**Consultation Response from KC,
Trees****2025/92943 Tam House, 49, Brow Road, Paddock, Huddersfield, HD1 4TP****Erection of 2 light industrial starter units****Date Responded: 24/11/2025****Responding Officer: JD****Responding Ref:**

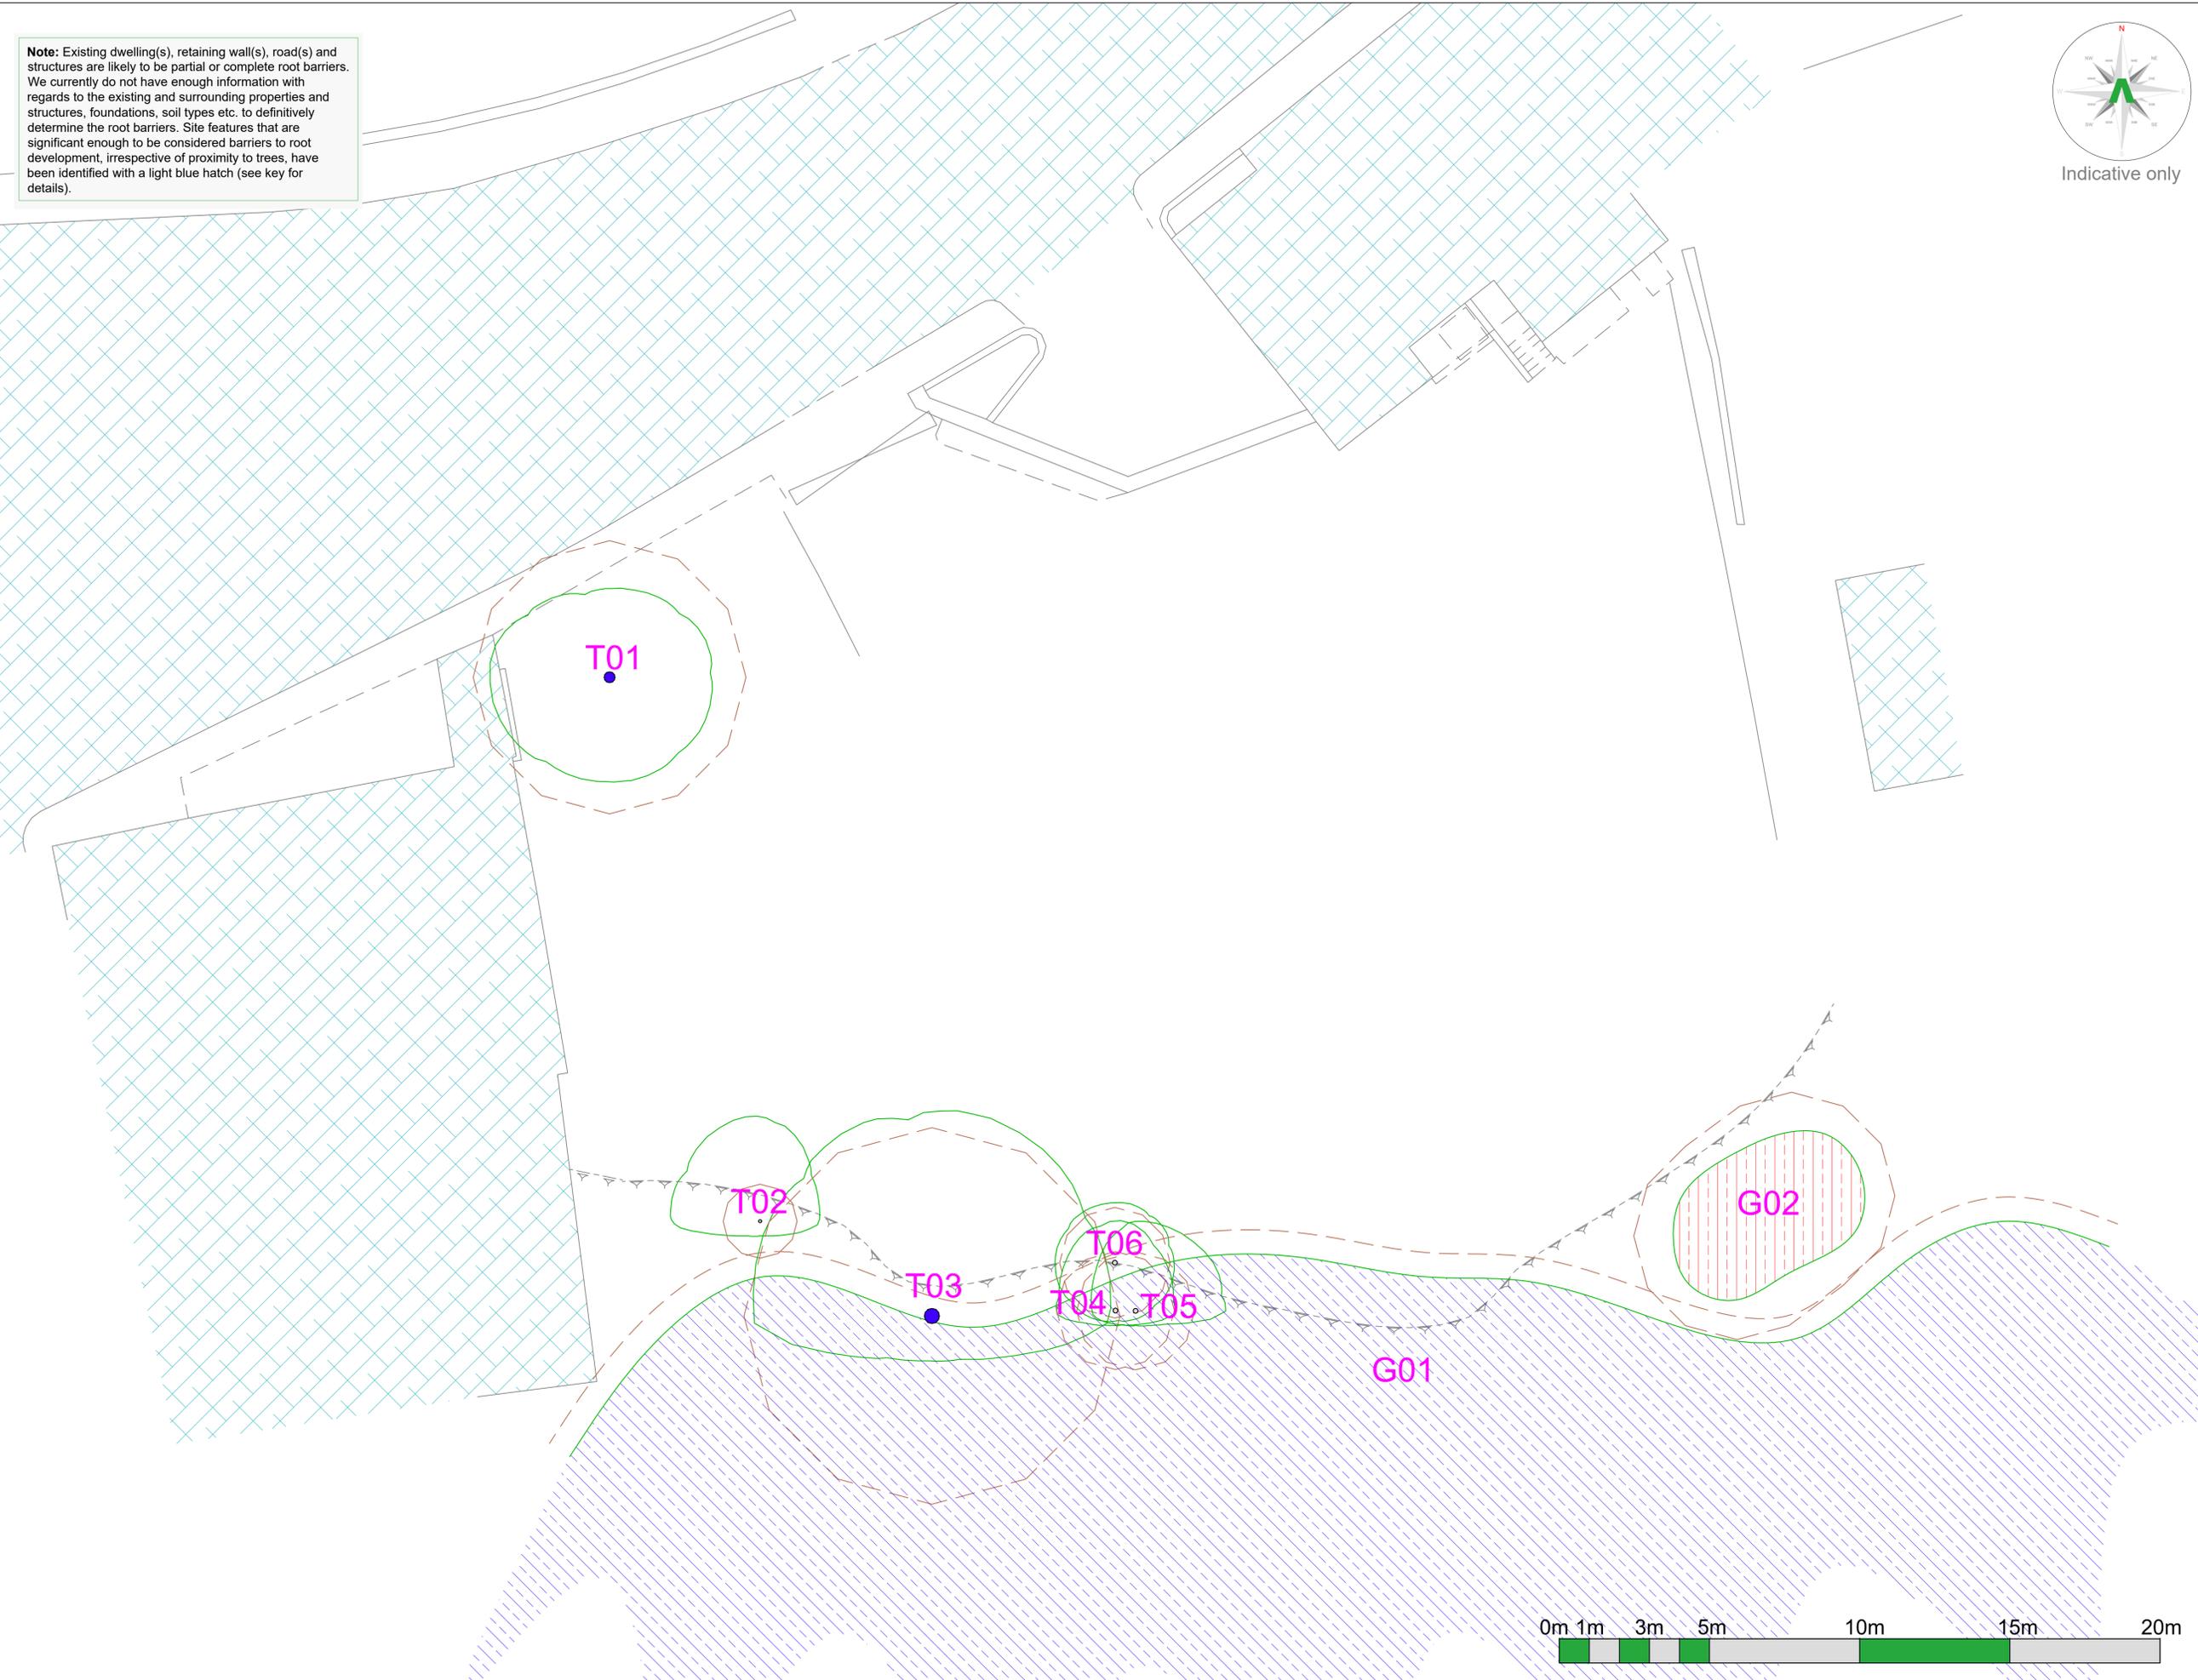
Whilst a tree survey and tree protection method statement have been submitted the absence of an Arboricultural Impact Assessment (AIA) makes it impossible to actually assess the impact on the surrounding trees. It appears as if T3 is to be removed to facilitate the development. KC trees is not convinced that this category B tree could not be retained as part of the plans.

There is a holding objection until an AIA and tree protection plan are submitted to BS5837 standard.
